SUBMISSION - NORTHCONNEX

NorthConnex EIS Submission

Director - Infrastructure Projects
Department of Planning and Environment
Number: SSI 13_6136
Major Projects Assessment
GPO Box 39
SYDNEY NSW 2001

NorthConnex Application Number: SSI 13_6136

M1-M2-5000-DR-UD-0556
NORTHERN VENTILATION FACILITY - LONG SECTION

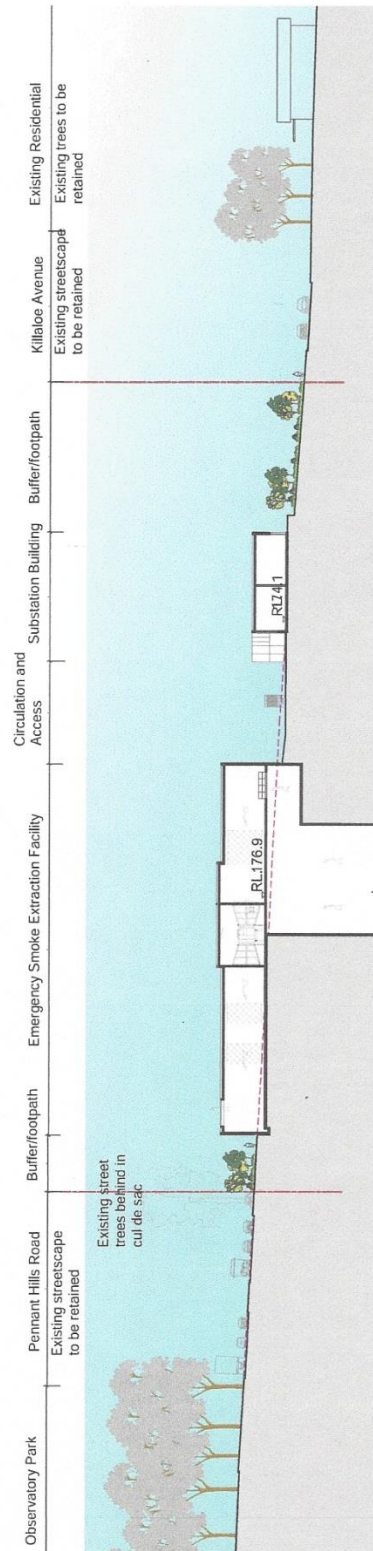
- The placement of the northern ventilation stack in the Wahroonga valley where there are often low wind speeds will result in poor dispersion and community exposure to high levels of tunnel emission. A majority of heavy air pollution will have gravitation sedimentation within a distance of 50m to 1500m around the stack

The placement of the Northern ventilation stack in the Wahroonga valley where there are often low wind speeds, in particular on calm days with average wind speeds of 2 to 5 km/hour, which will result in the poor dispersion of air pollution and high emission exposure to the community. I have calculated that the majority of heavy air pollutions will have gravitation sedimentation within a distance of 50m to 1500m around the stack, refer to Appendix C - Simplified Calculation for Air Pollution Gravitational Sedimentation around Stack.

Importantly, I would like to propose an alternative 'cut & cover' tunnel extension & relocate Northbound portal & stack into bush land & industrial zone, please find the attached "Appendix E- Alternative 'Cut & Cover' Tunnel" design sketch for your consideration. I have briefly listed some advantages of my alternate design below:
